DRB Application No.: 05DRB-00008 (P&F)

Project Name: ALBUQUERQUE HIGHLANDS

**CITY OF ALBUQUERQUE
PLANNING DEPARTMENT
1/12/05 DRB Comments**

RE: Block 12, Albuquerque Highlands/minor plat

PLAT OF
LOTS 4-A & 4-B, BLOCK 12
 (BEING A REPLAT OF THE WEST 63' OF LOT 4, BLOCK 12)
 ALBUQUERQUE HIGHLANDS
 ALBUQUERQUE, BERNALILLO COUNTY, NEW MEXICO
 OCTOBER, 2004

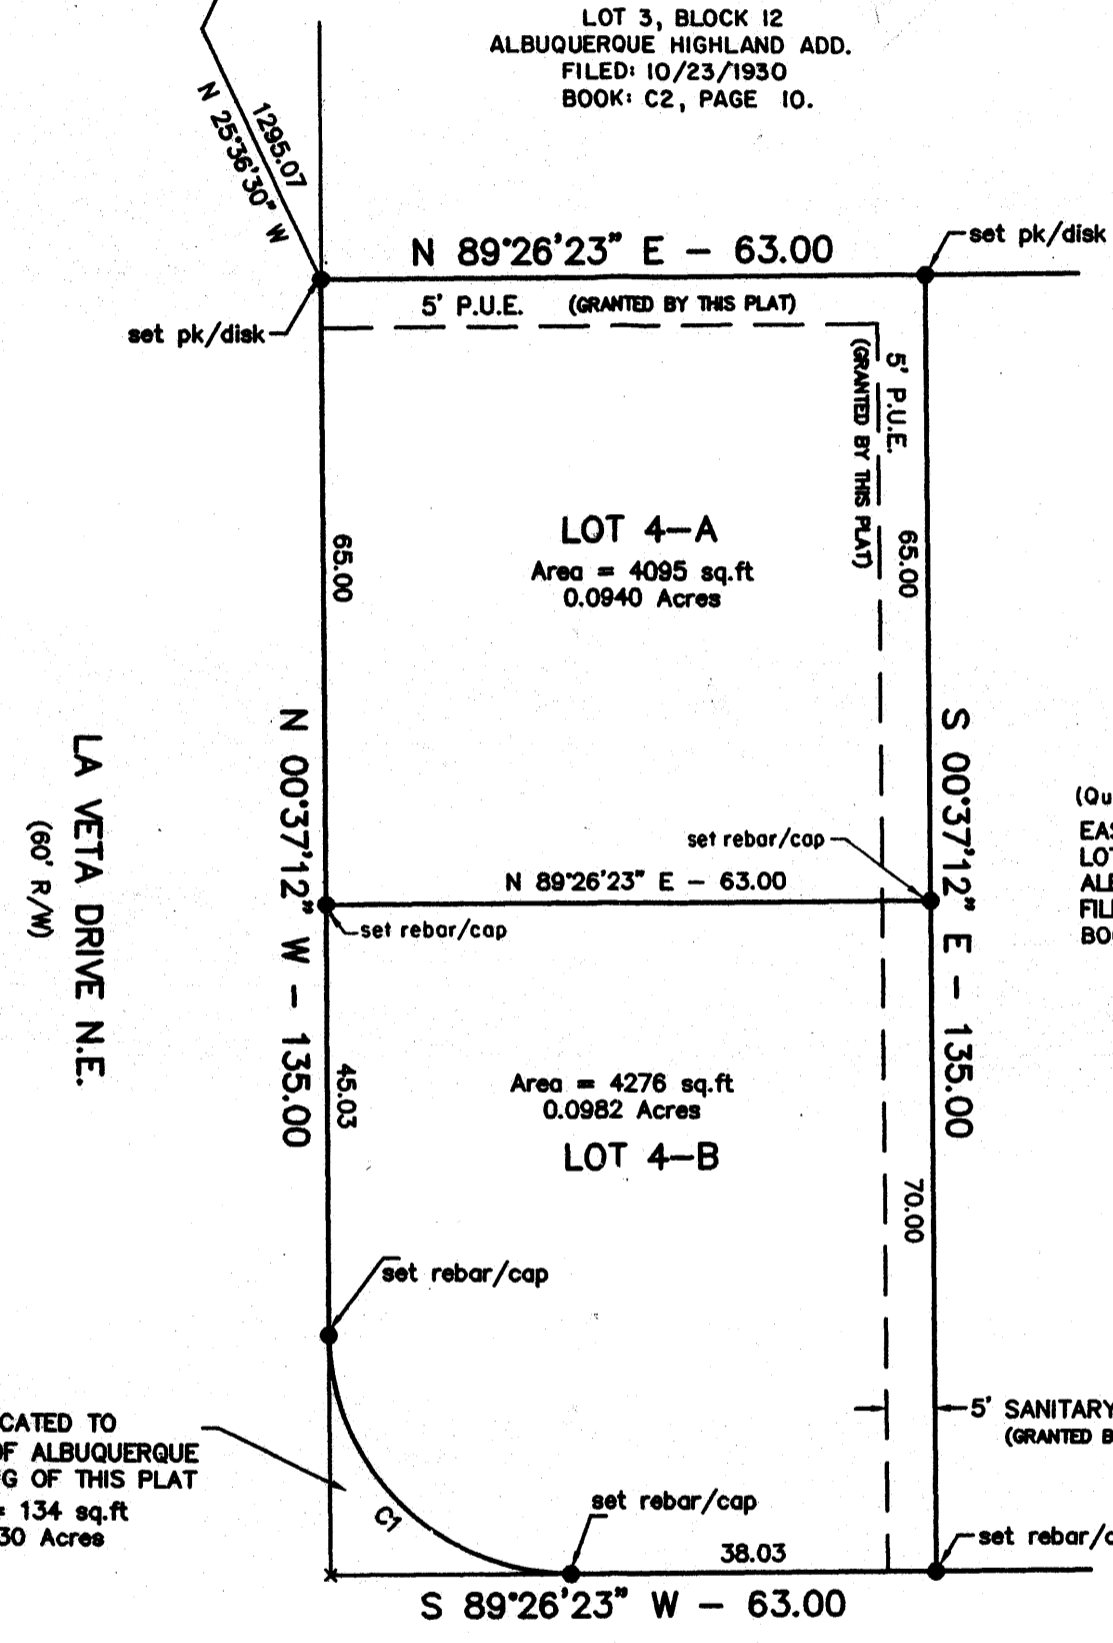
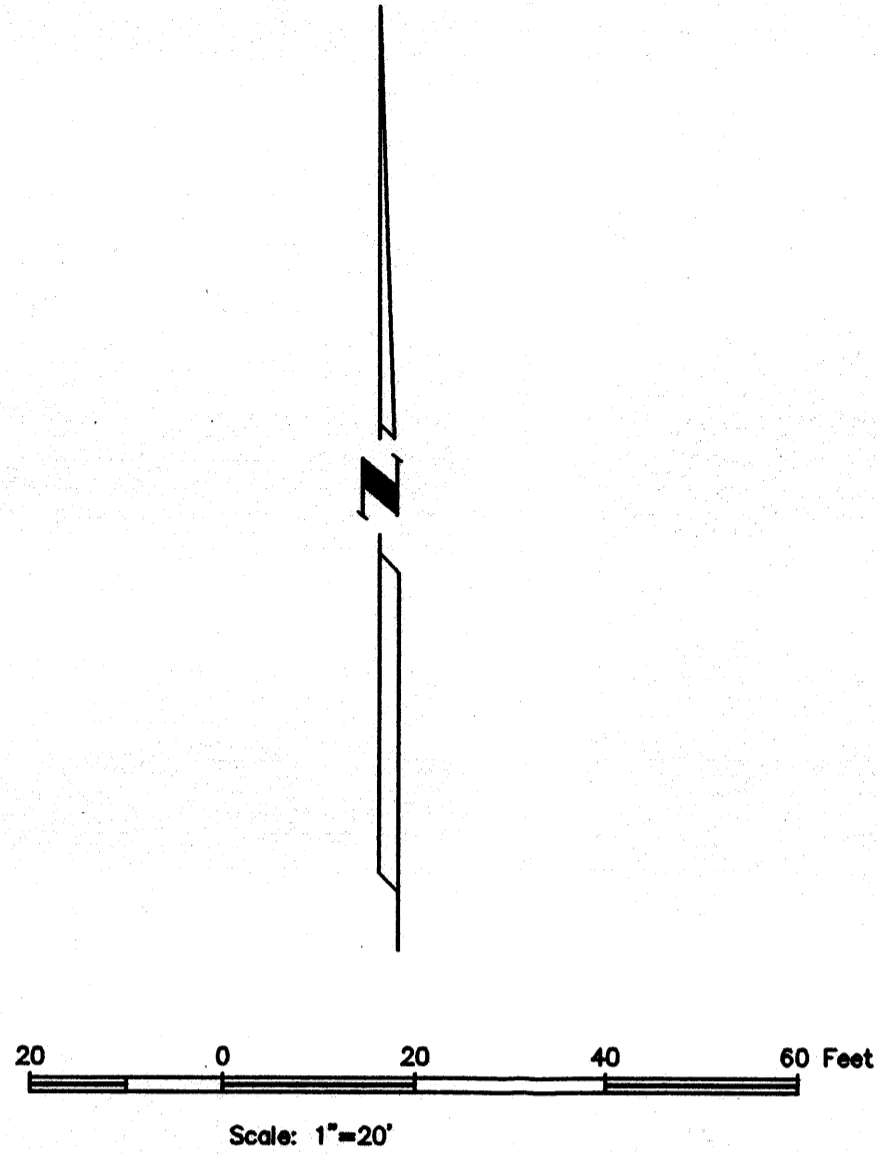
The two lots are too small for R-1 zoned lots. DRB cannot approve a replat if the lot sizes do not conform to zoning lot size requirements. The minimum lot size is 5,000 square feet with a 50' minimum lot width providing there is a pattern of smaller R-1 zoned lots in the area. Otherwise, the minimum lot size is 6,000 square feet with a 60' lot minimum lot width.

In addition, any existing or planned residences must meet R-1 setback requirements.
